MMC Visitor Garage and East Tower Project - Initial Traffic Comments

Hi Jean – the following outlines my initial comments as it relates to the above noted project. Please note that the comments do not include a review of the Congress Street Traffic Control Plan.

CONSTRUCTION ACCESS GATE

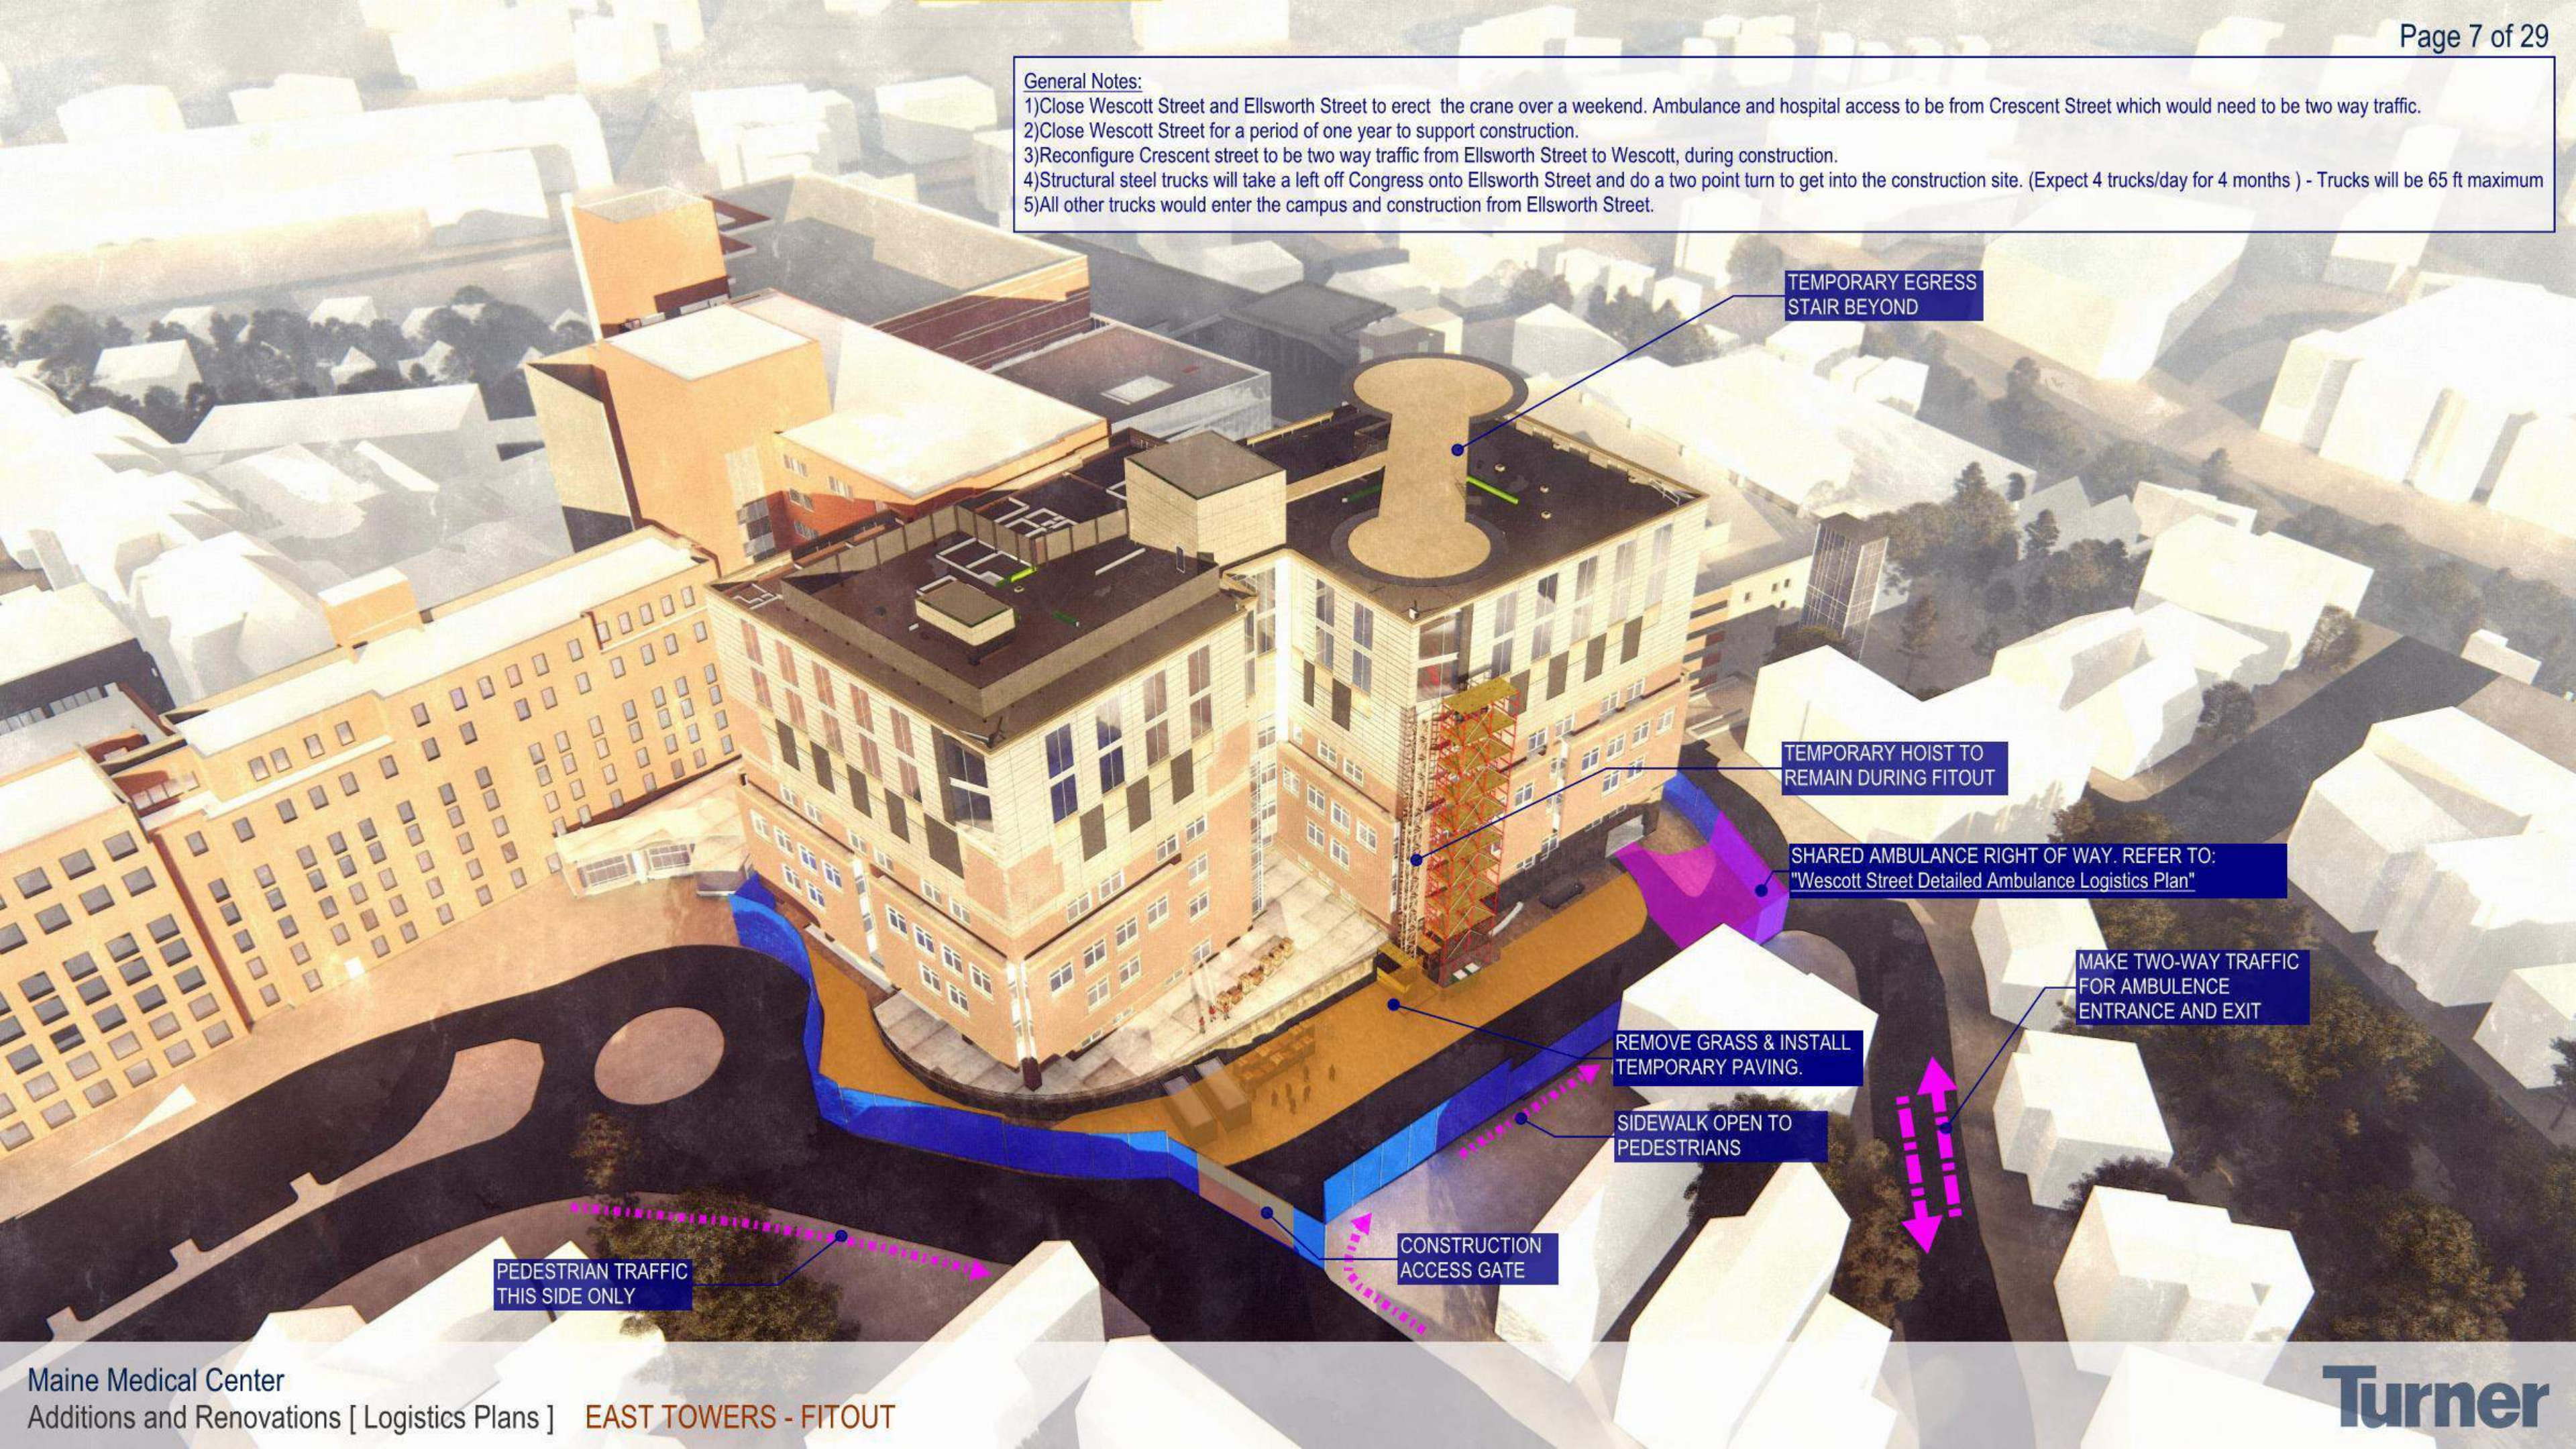
- The following are initial East Tower Traffic Control Plan comments:
 - The City does not support the conversion of Ellsworth Street to two-way flow between Congress Street and Crescent Street. The applicant has noted this to be acceptable. The plans should be revised to reflect this change.

- It is unclear if the bump out at the Crescent Street/Wescott Street intersection is to be removed. If it is to remain, vehicle turning templates should be provided for review and approval.

**MMC HOSPITAL EXPANSION  
 EAST TOWER OVERBUILD  
 STRUCTURAL STEEL  
 TRUCK ROUTE FROM I-295N TO MMC SITE ON  
 WESCOTT STREET  
 1-295 N TO WASHINGTON AVE. TO CONGRESS  
 STREET TO ELLSWORTH STREET TO  
 WESCOTT STREET SITE**

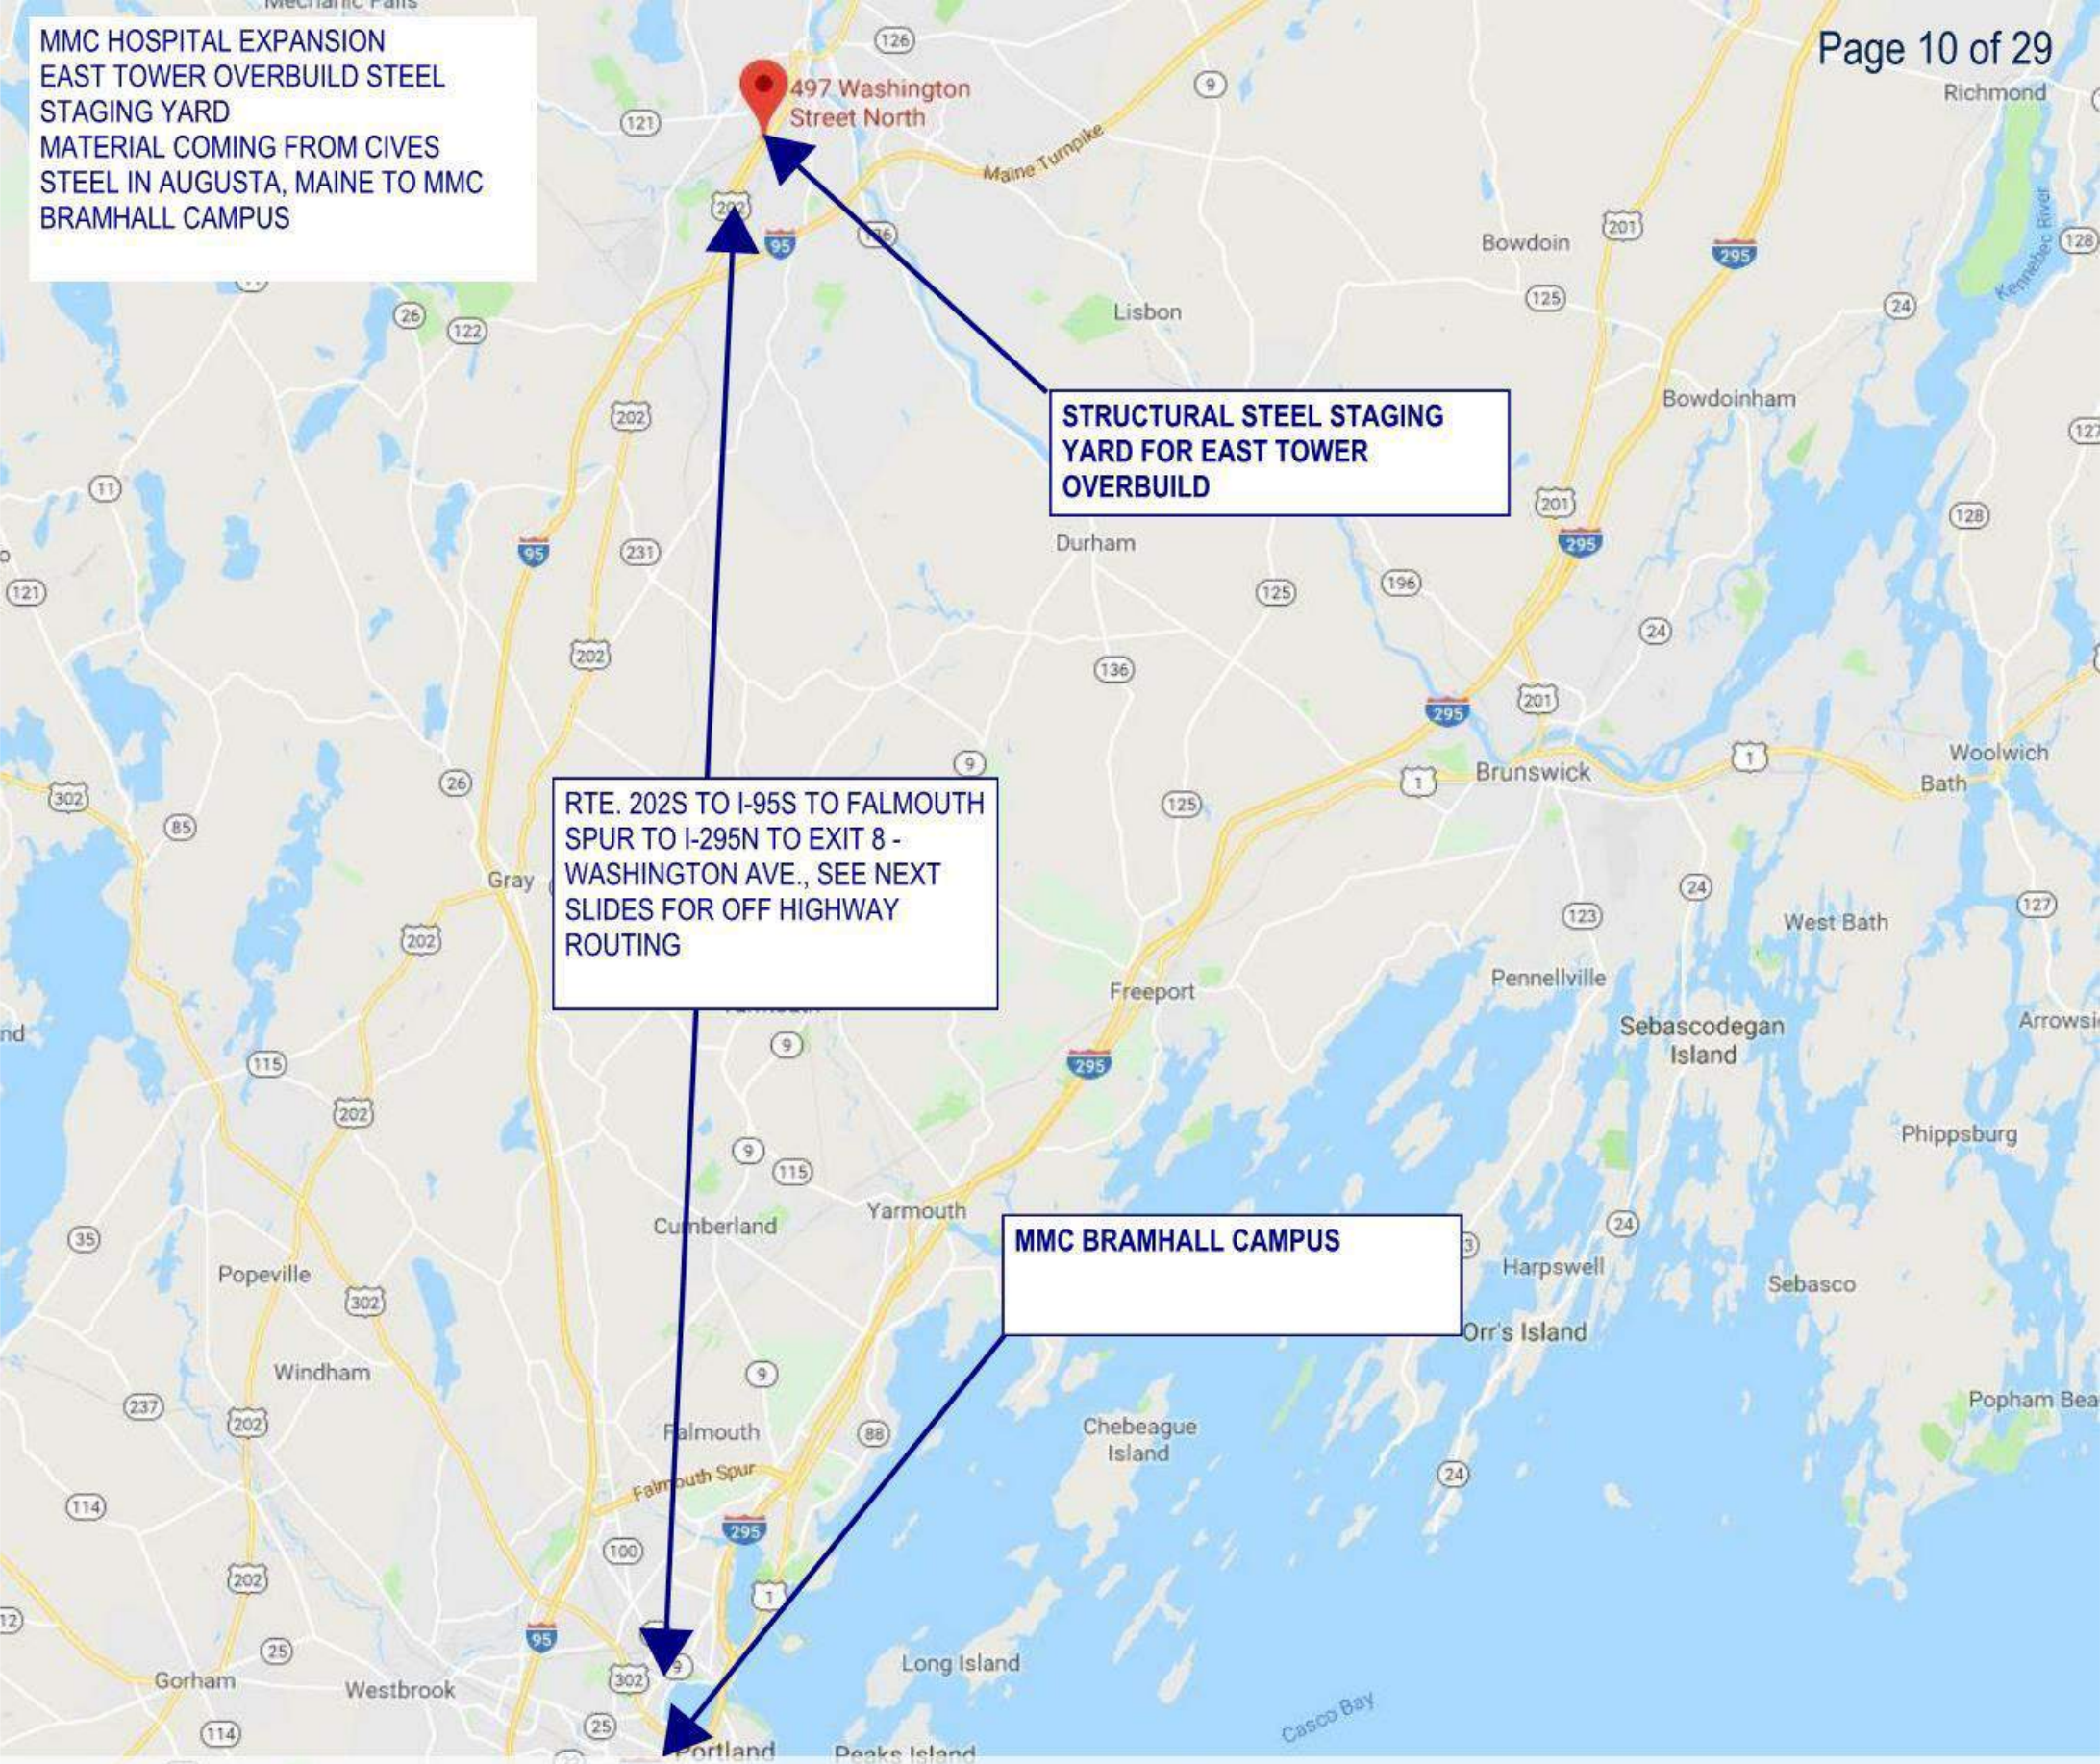
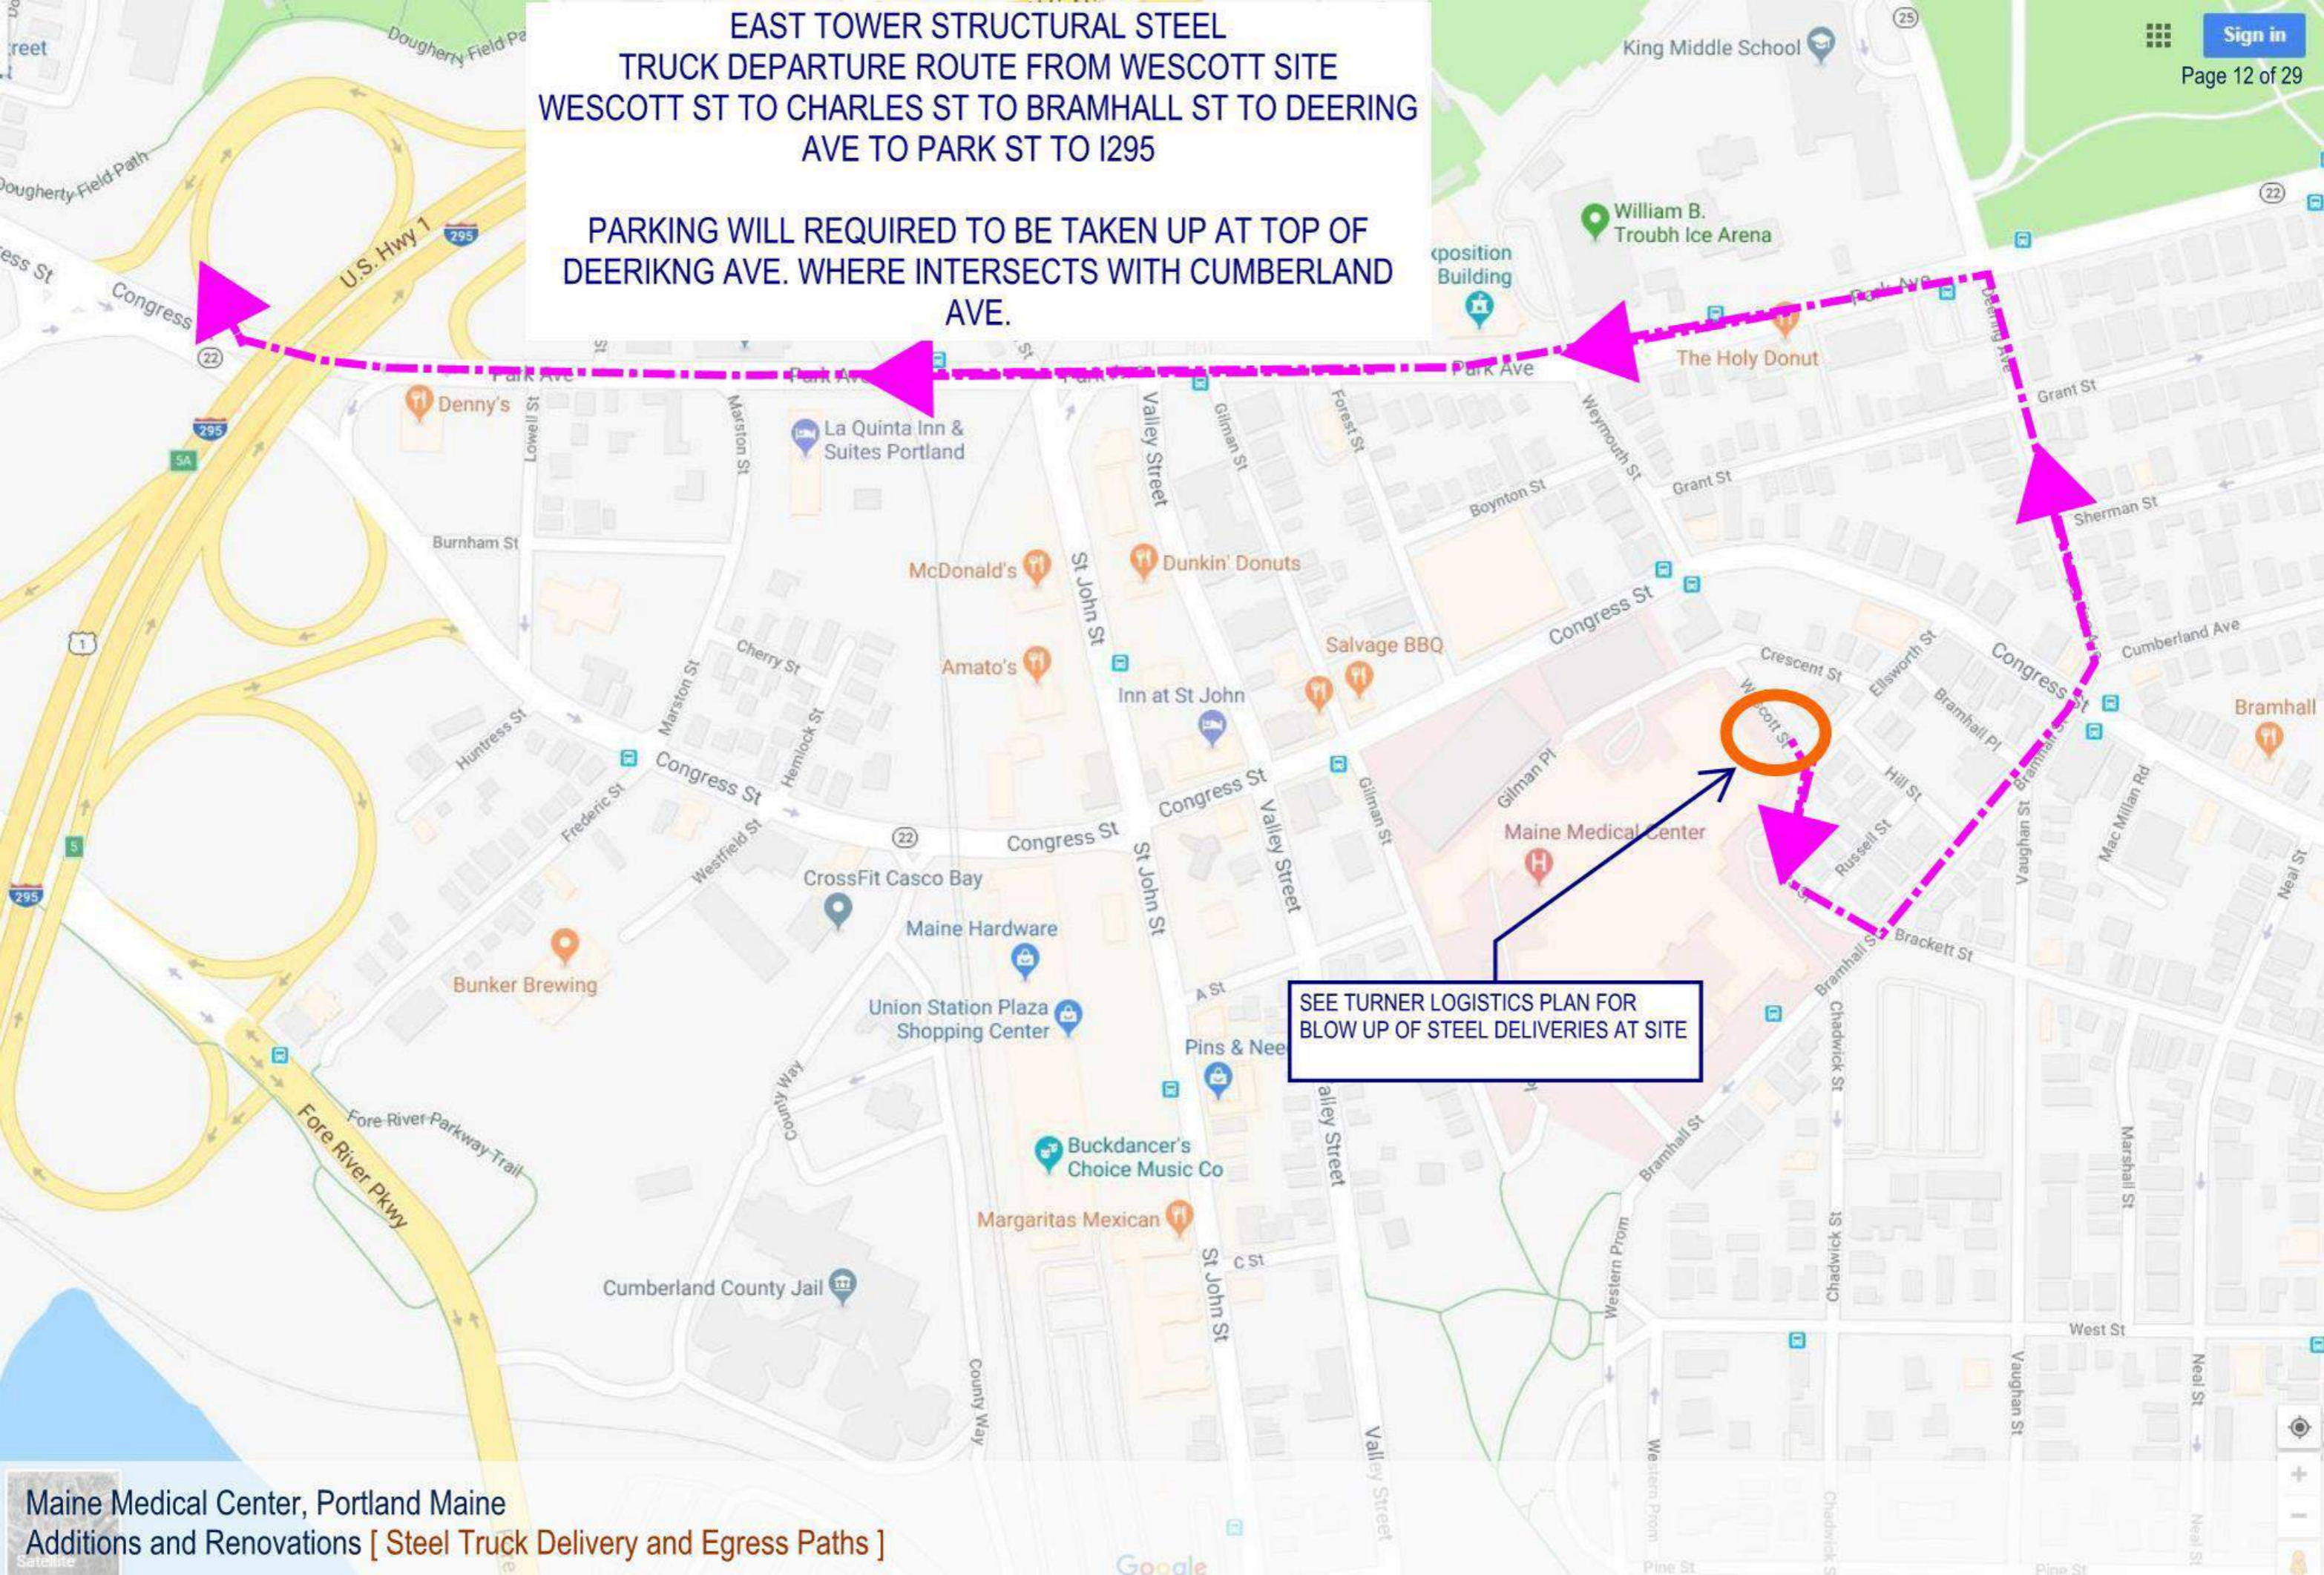
- Detailed routing and vehicle turning information for truck deliveries shall be provided for review and approval.
 - It is my understanding that the Fire Department will be providing comments regarding concerns for Emergency Department vehicle access.
